Re – Application number AW/344/14/HH, 68 The Drive, Aldwick.

I wish to register my objection to the developments proposed in the above application as they are not in keeping with the development requirements within the conservation area.

SOUTH & EAST ELEVATIONS
EXISTING & PROPOSED.

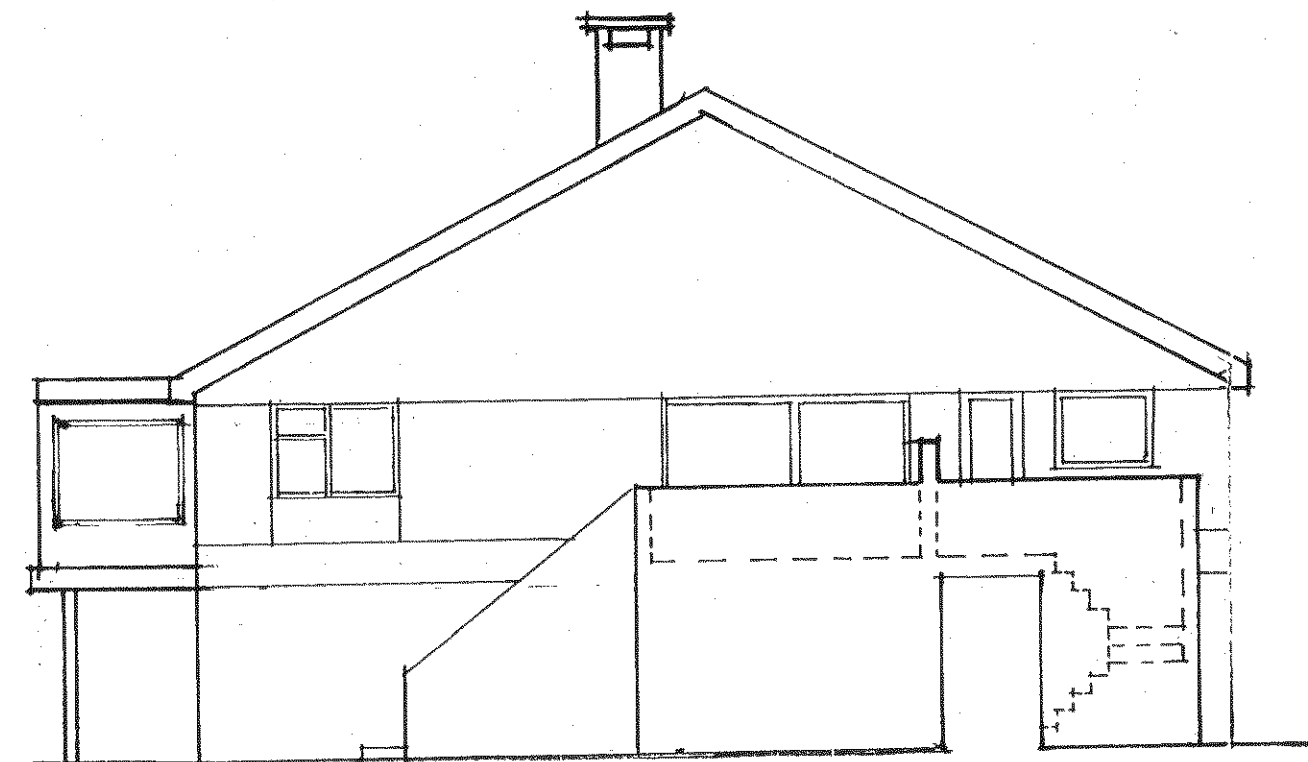
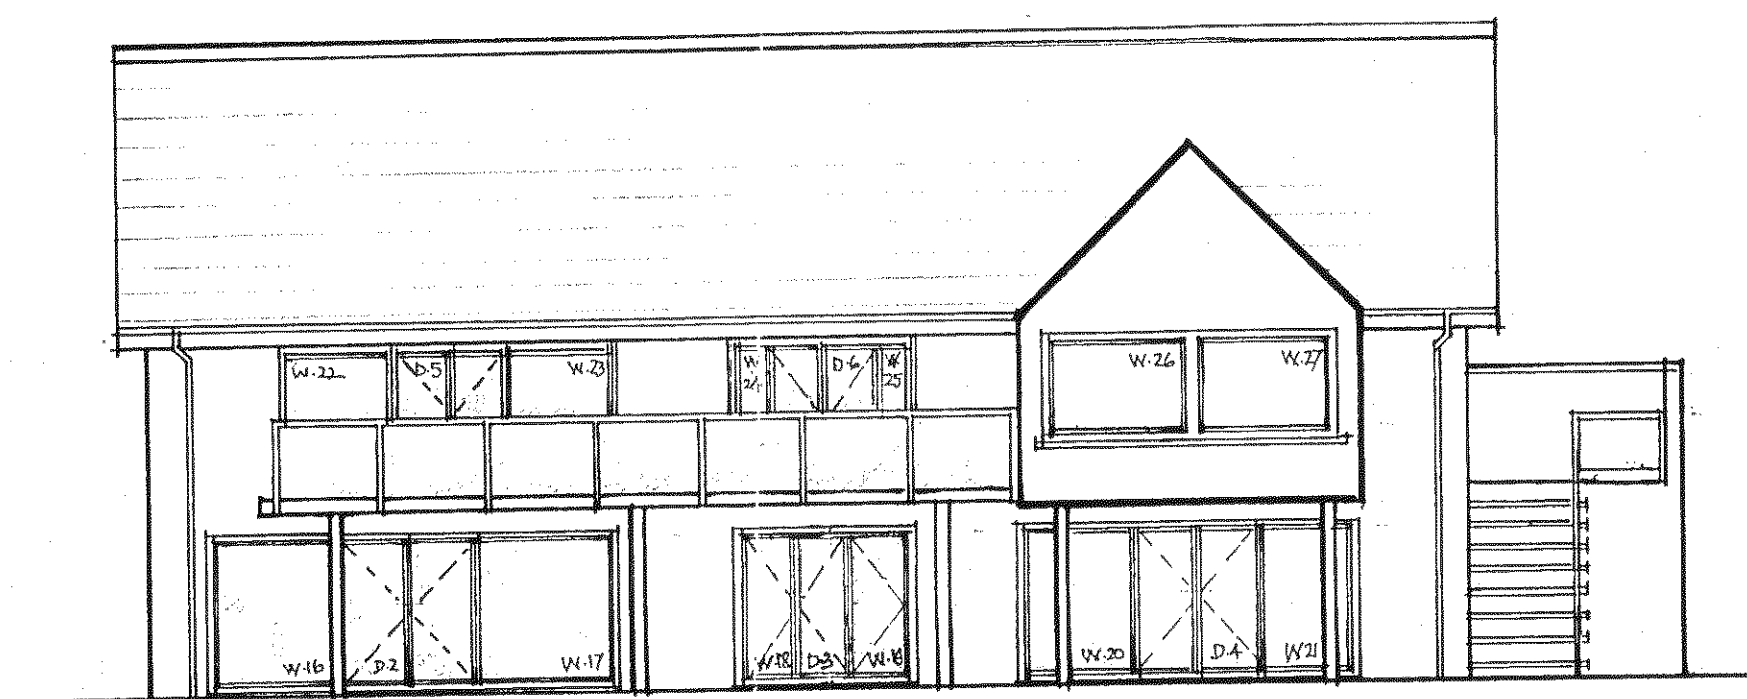
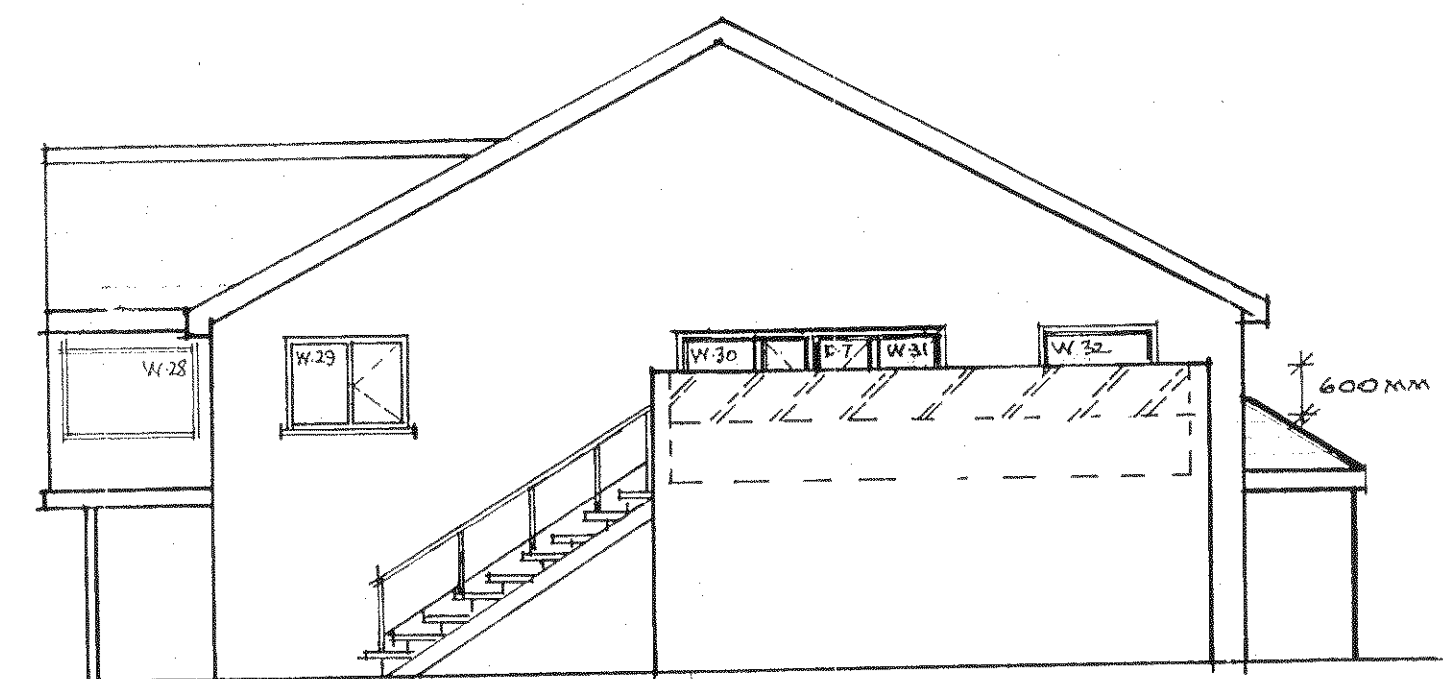
In particular the removal of the staircase to the south elevation and the replacement of the brick built staircase on the eastern elevation with a stainless steel and glass staircase is likely to increase movements of people close to the adjacent property and to make them more visible and will be a further intrusion into the privacy of the owners of number 70. The Conservation Area Plan makes reference to the spaciousness between dwellings being a characteristic of the estate, the creation of a larger terrace area will further reduce the spaciousness. The situation would be considerably improved if the external staircase and the terrace area were removed completely being replaced either by an access inside the building, or a simple enclosed staircase still on the eastern elevation or better still retaining the staircase on the south elevation as the sole external means of moving from ground to first floor level. This latter would indicate that the developer was mindful of the impact of the renovations on the neighbours as well as improving the spaciousness between the properties, which is to be desired and would make a positive contribution.

Under Amenity (iii) there is a requirement that plans "do not have an adverse, overshadowing, overlooking or overbearing effect on neighbouring properties". These proposals do not satisfy this requirement.

Policy GEN 7 para (iv) states "does not have an unacceptable adverse impact on adjoining occupiers, land, uses or property....." and at (v) takes account of any unacceptable adverse impacts.....". These conditions are not complied with in these plans.
